Application Reference: 2025/0436

Site Address: 95 Strafford Avenue, Elsecar, Barnsley, S74 8AL

Introduction: Erection of 2 sheds to use as workshop and games room.

APPLICATION NUMBER 2025/0436 QS STRAFFORD AVENUE ELSECAR BARNESLEY S79 8AL
 NW = NEW WORKSHOP. SCALE 1:50

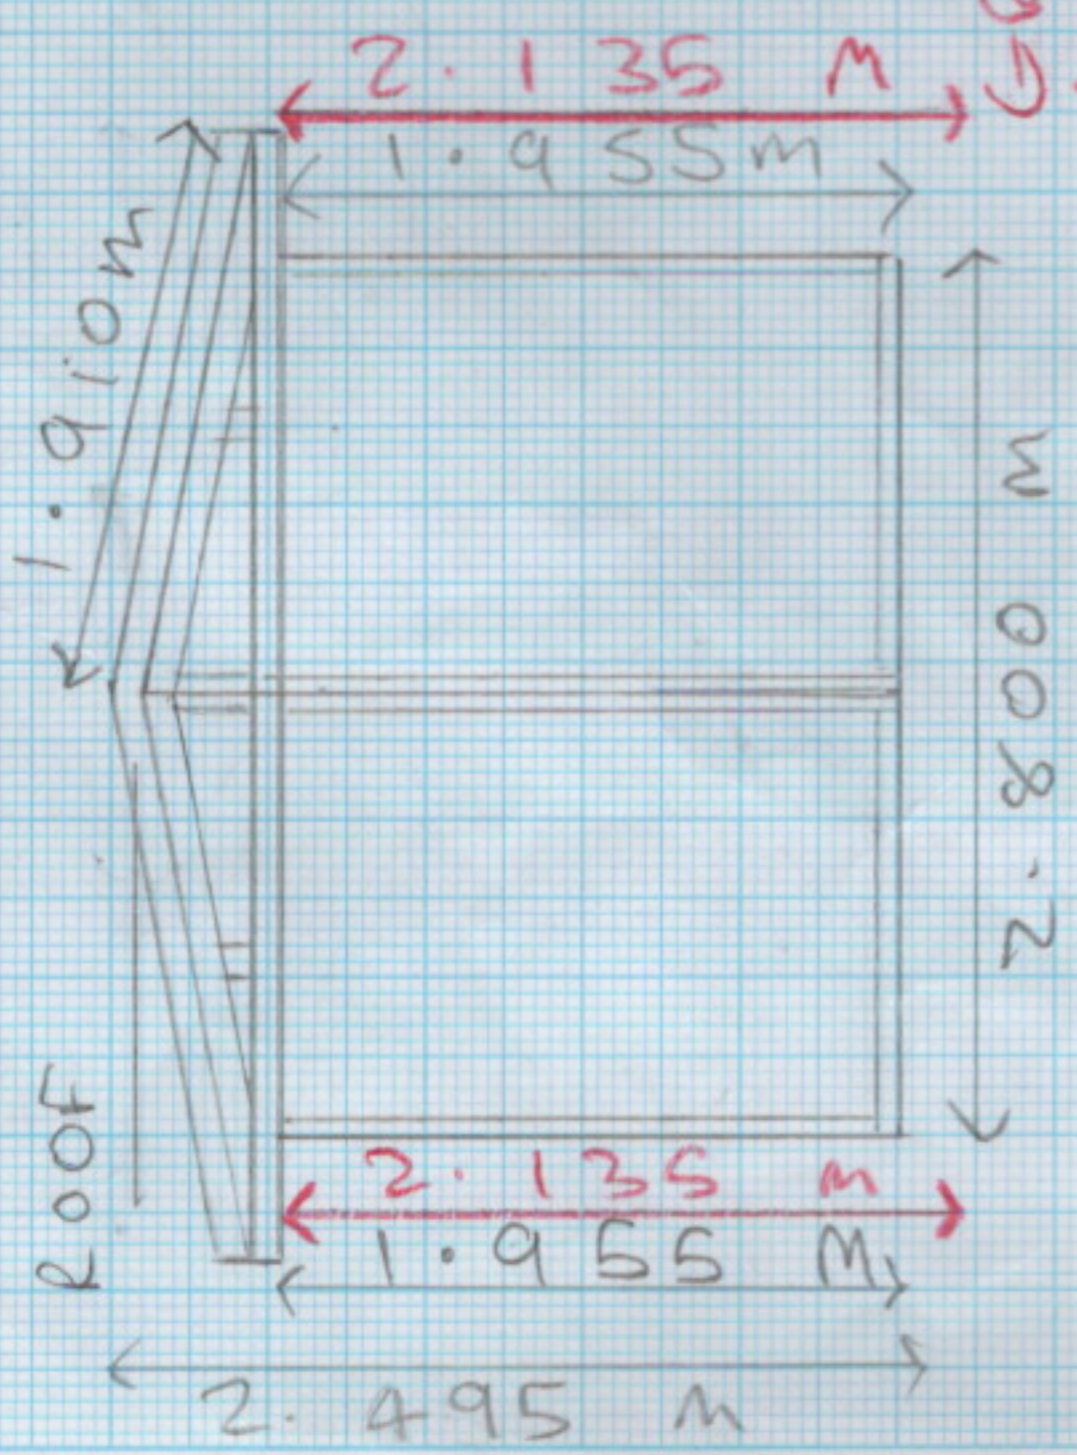
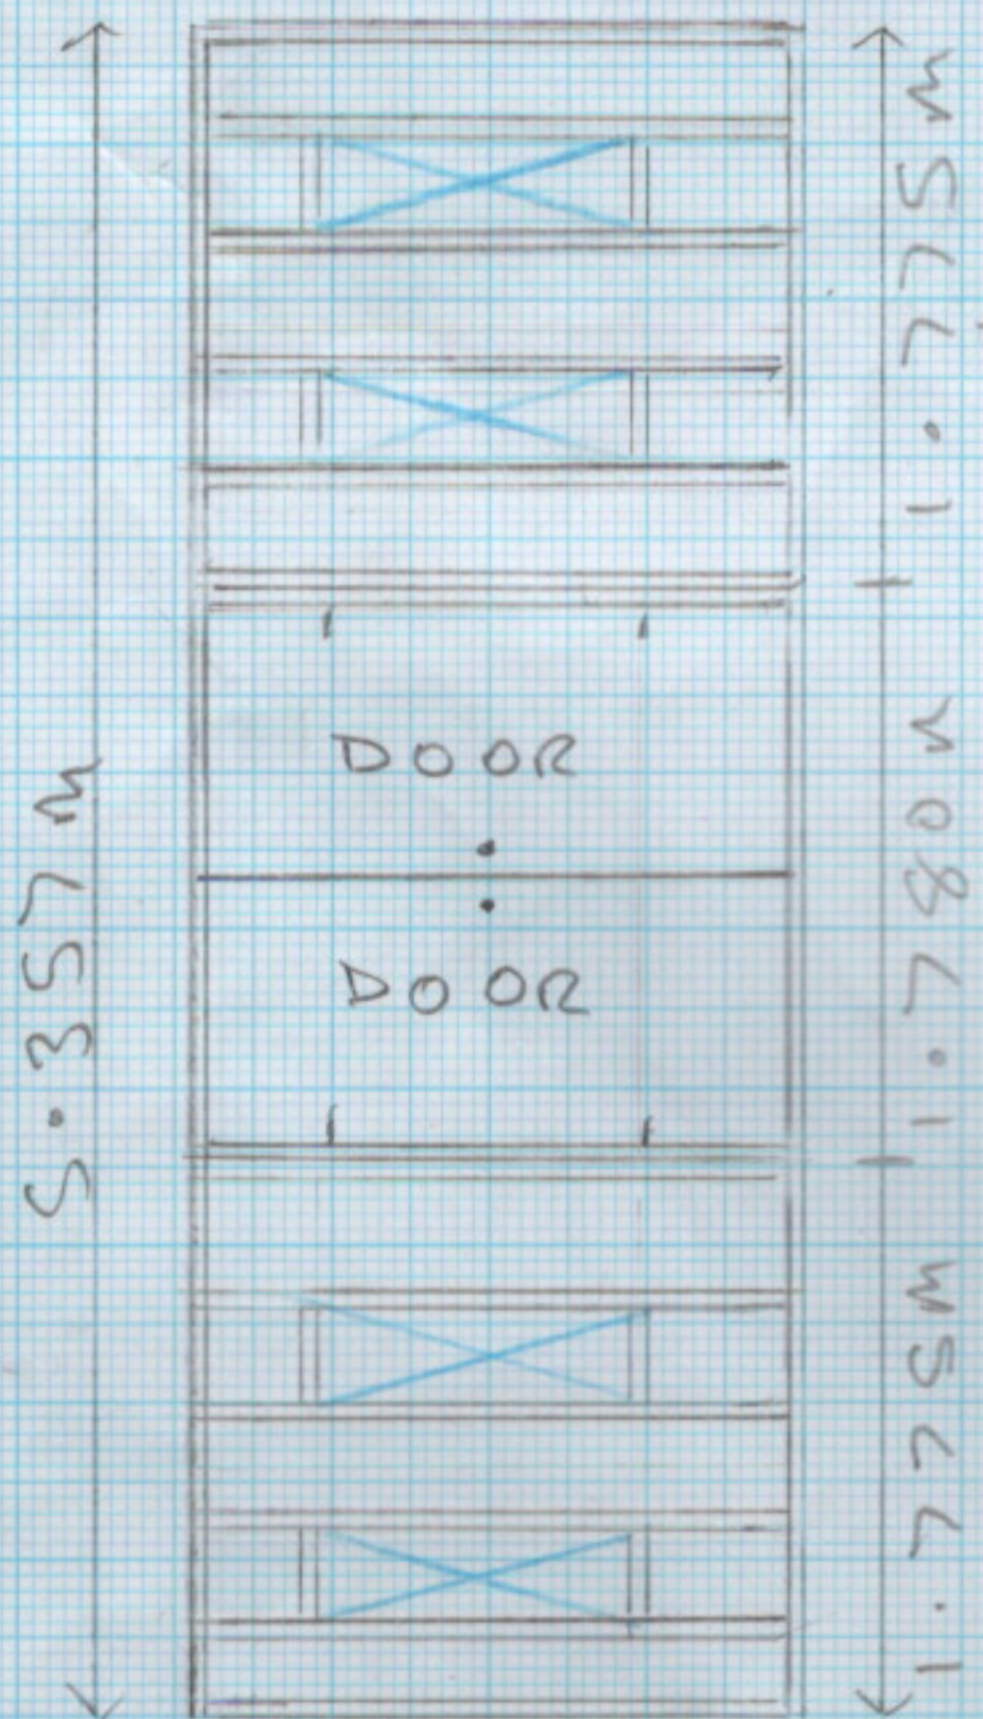
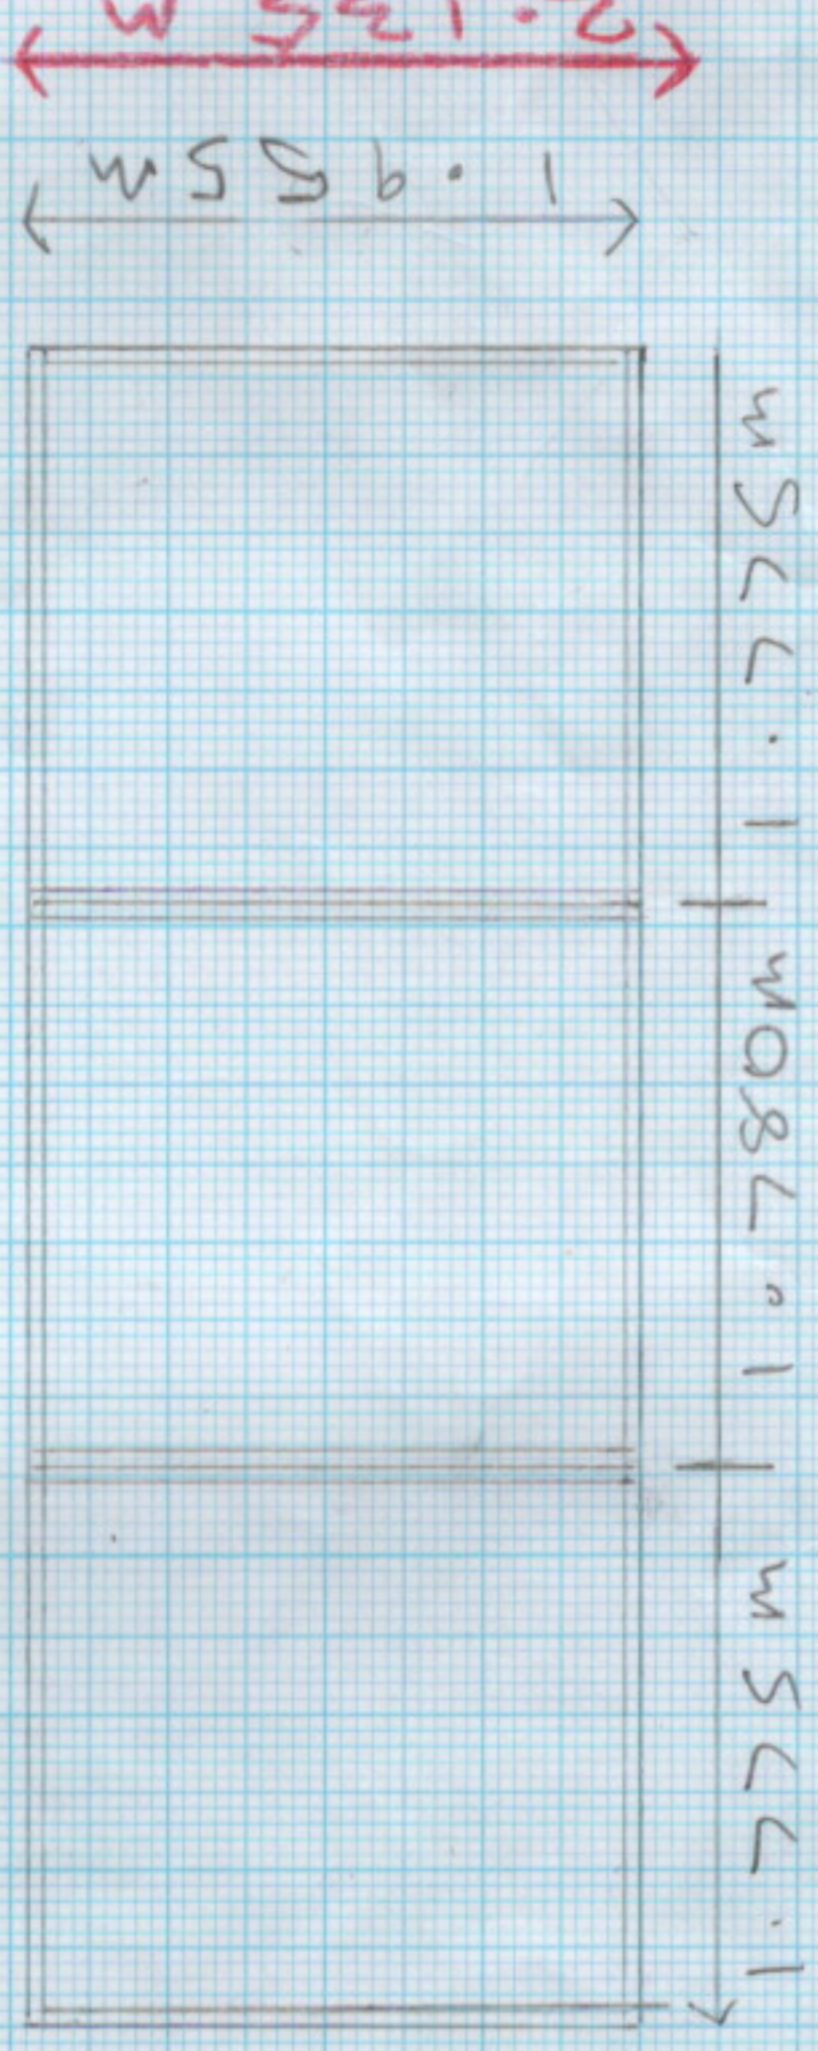
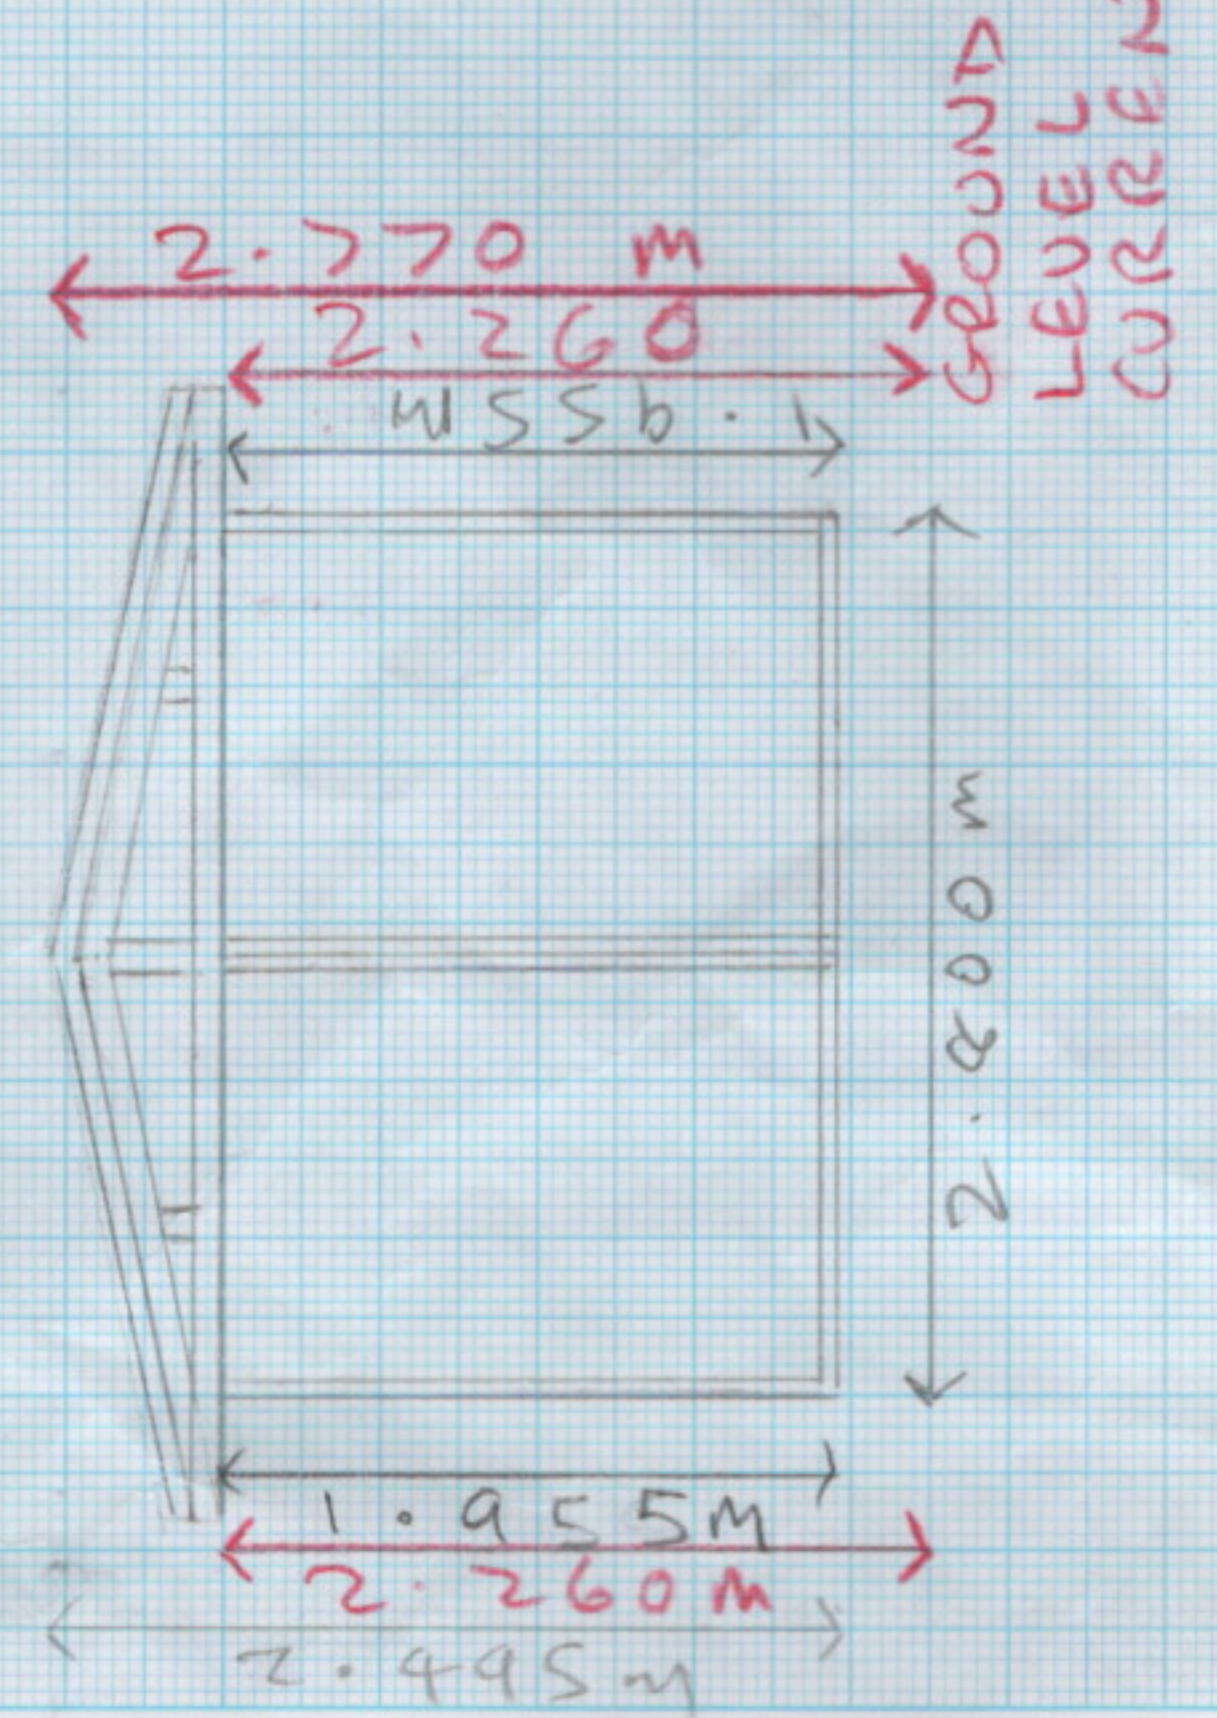
The applicant is seeking permission to erect two outbuildings. The New Workshop and the New Games Room. The New Workshop would have an approximate floor space of 22.3 square metres, an approximate total height of 2.77 metres and an approximate eaves height of 2.26 metres. A pitched roof has been detailed. Four elongated windows are detailed to the east elevation of the outbuilding, two either side of the proposed doors spanning 1.78 metres.

The proposed two proposed outbuildings would be erected within close proximity to the neighbouring boundary to the west. The size and scale of the outbuildings are not likely to cause any issues in terms of loss of light or outlook. The height of approximately 2.77 metres is less than the maximum 4 metres for outbuildings as outlined within the House Extensions SPD and the eaves heights of approximately 2.26 and 2.26 metres is also less than the maximum eaves height of 2.5 metres. These heights are not significantly greater than the existing boundary treatment and would not be impactful enough to cause detrimental harm to loss of outlook and sunlight.

The proposed new outbuildings are detailed to a scale in line with the House Extensions SPD. The height of approximately 2.77 metres is less than the maximum 4 metres outlined within the House Extensions SPD and the eaves heights of approximately 2.26 and 2.26 metres is also less than the maximum eaves height of 2.5 metres. The use of wood materials does not match the material of the site dwelling, however wooden sheds are common feature of residential gardens and are not considered detrimental to the character of the site, especially given they cannot be seen from the street scene.

The addition of the proposed new outbuildings would increase the cumulative floor space to approximately 81 square metres, approximately 69% of the total curtilage. Given the accumulation of the floor space taken up by the existing outbuildings and the proposed new outbuildings, it is considered the development at the site to be excessive and to take up a disproportionate amount of private rear garden space. It is acknowledged the erection of the two proposed outbuildings has begun but is not yet completed.

It has been necessary to make contact with the applicant to request plans and elevation of the proposed New Workshop and New Games Room in order to obtain more accurate roof and eaves heights for accurate assessment of the proposal. This information was provided and resulted in amended plans and elevations.

In the opinion of the local planning authority, the cumulative impact of the erection of two new outbuildings for use as a workshop and games room alongside several existing outbuildings would result in a disproportionate amount of the rear garden being developed. The cumulative impact of the existing and new development would also have an overtly dominant impact on the character of the application dwelling to the detriment of visual
